| Application Ref: | 3/2025/0067 | | |  Ribble Valley Borough Council www.ribblevalley.gov.uk |
| DELEGATED ITEM FILE REPORT: | | | | APPROVAL |

| Development Description: | Change of use of land from an equestrian field (sui generis) to a dog exercise area (sui generis) including retrospective consent for an existing mesh fencing boundary treatment. |
| Site Address/Location: | Shaw House Farm, Clitheroe Road, Whalley, BB7 9AD. |

5563 - P01D

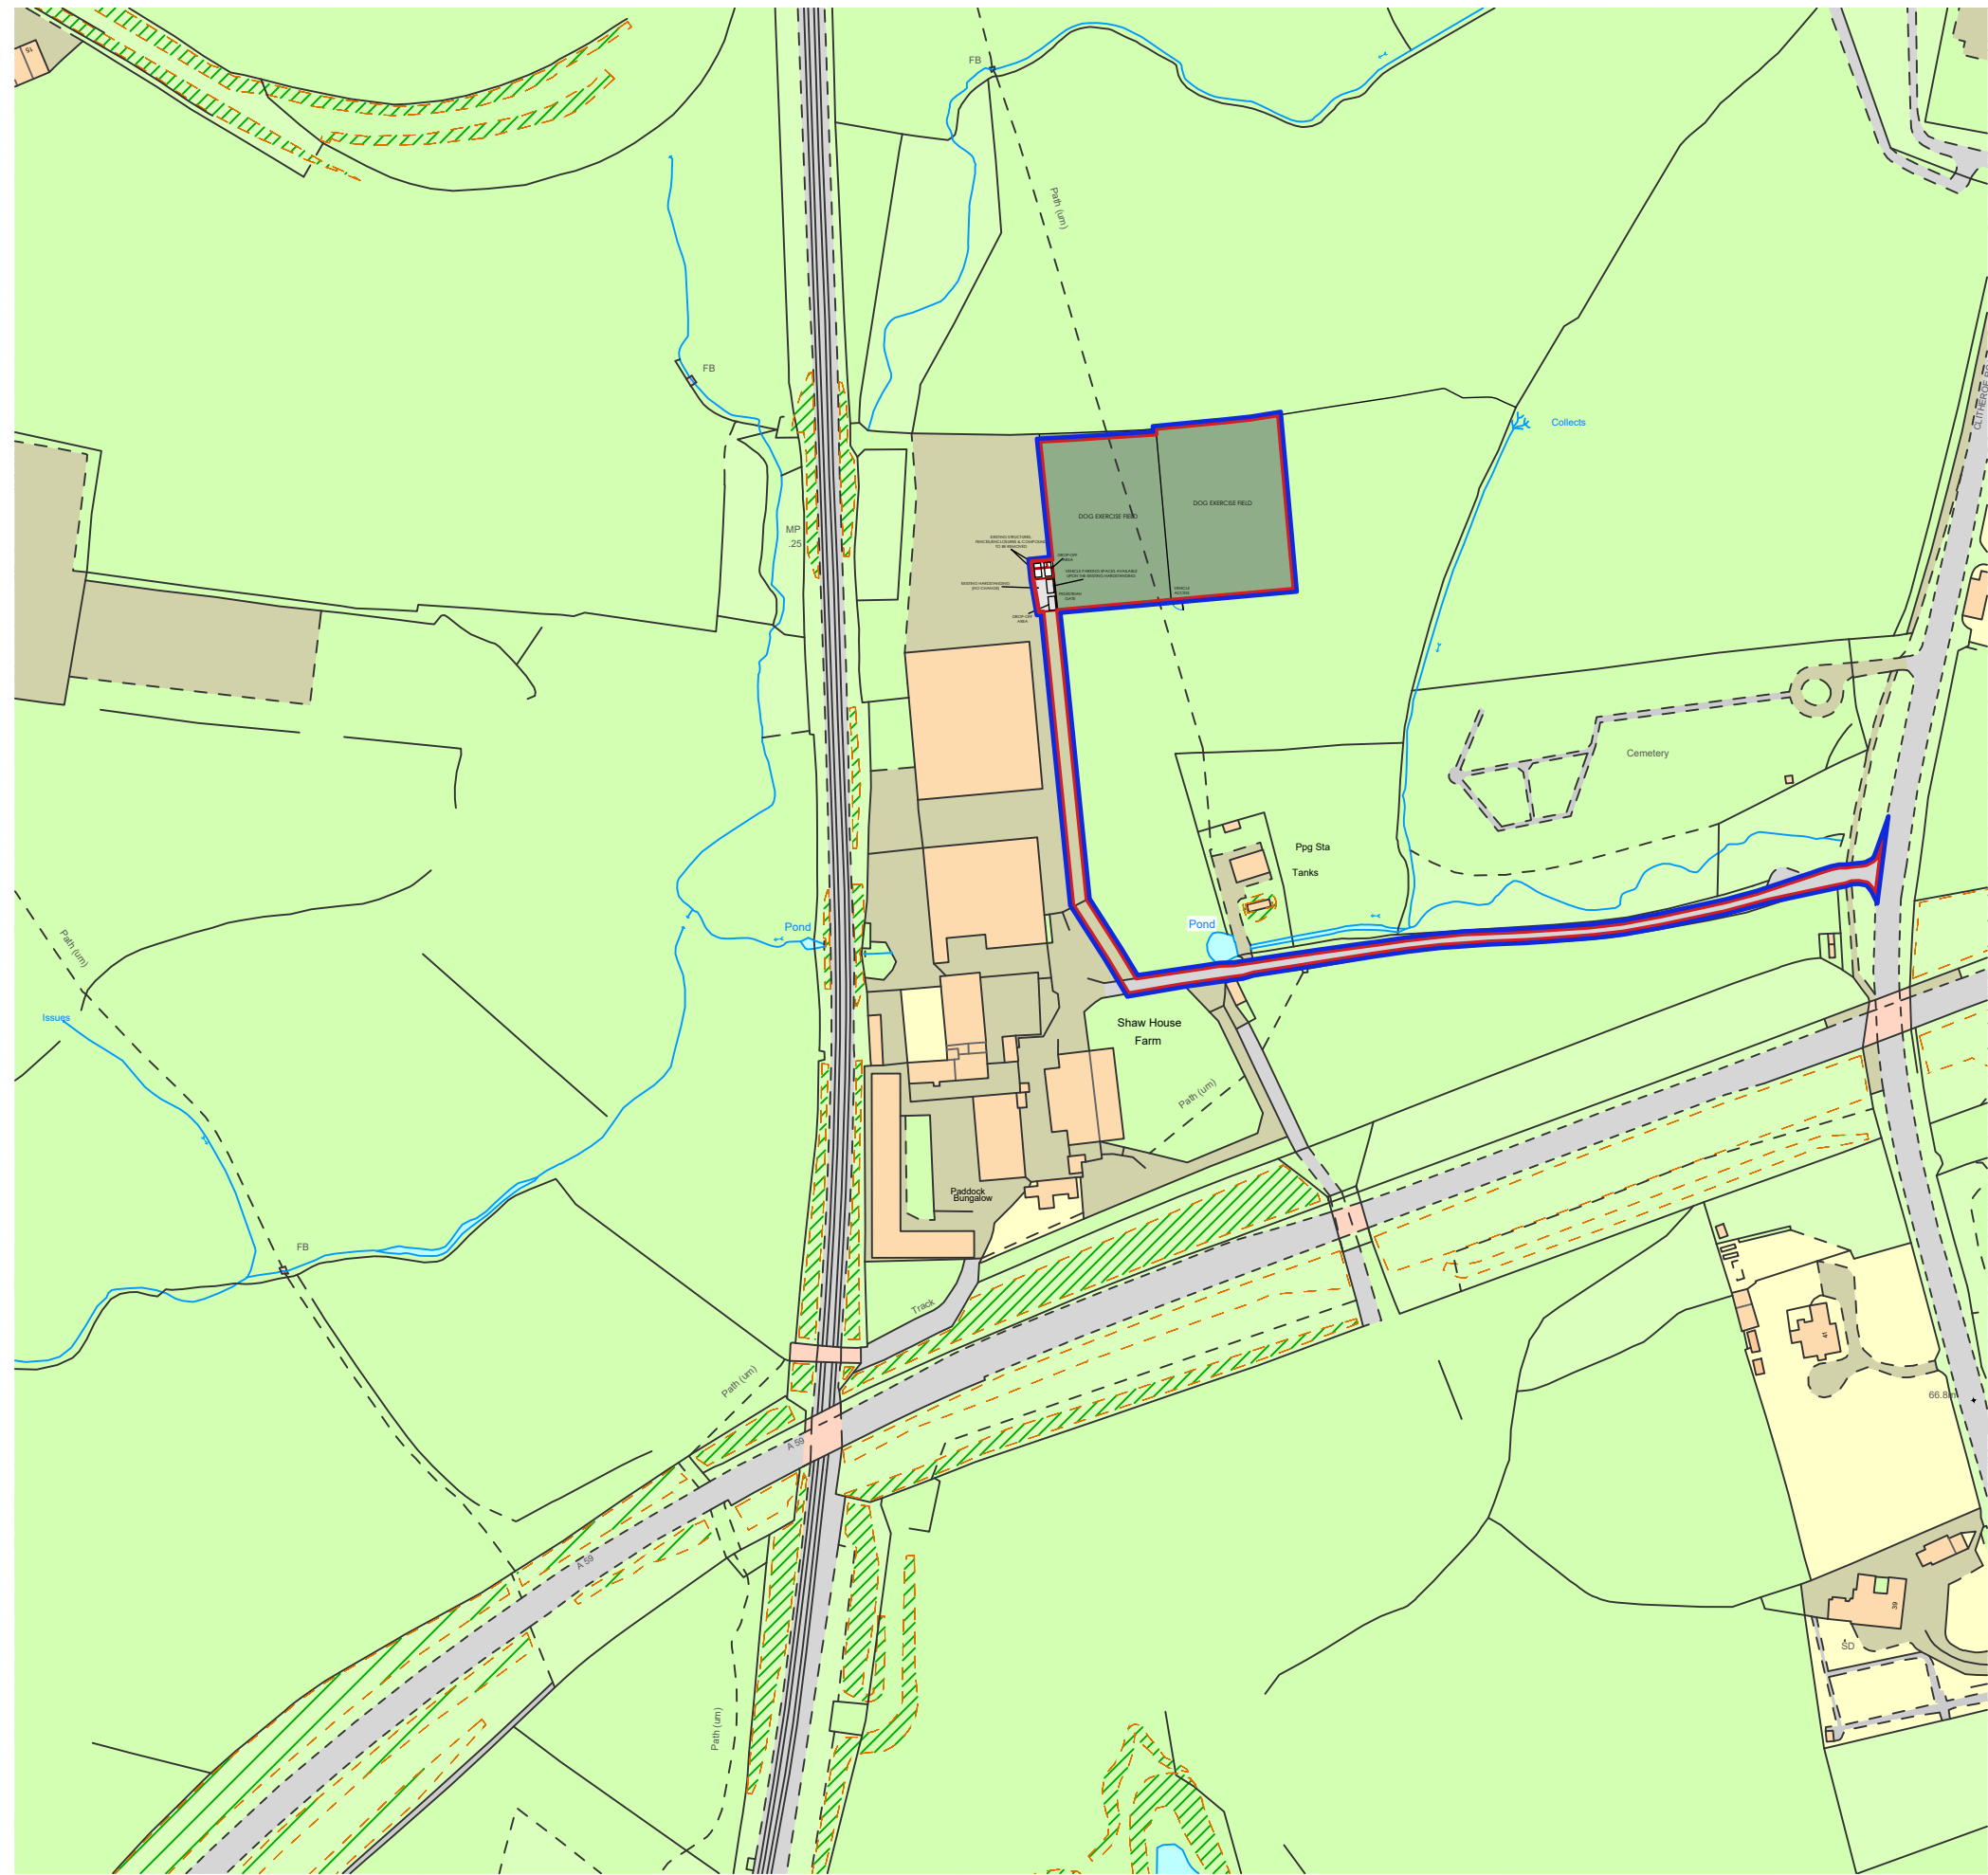
This was reviewed by the LHA who advised that more than one parking space was required on site in order to address any conflicting movements occurring, with three parking spaces being ideal alongside turning provision to allow enter and exit in a forward gear.

Following this, an amended site plan was received on 15th April 2026 showing four parking spaces provided within an existing hardstanding area. The LHA have confirmed that this would meet the demands for the site, considering the information provided within the operating statement.
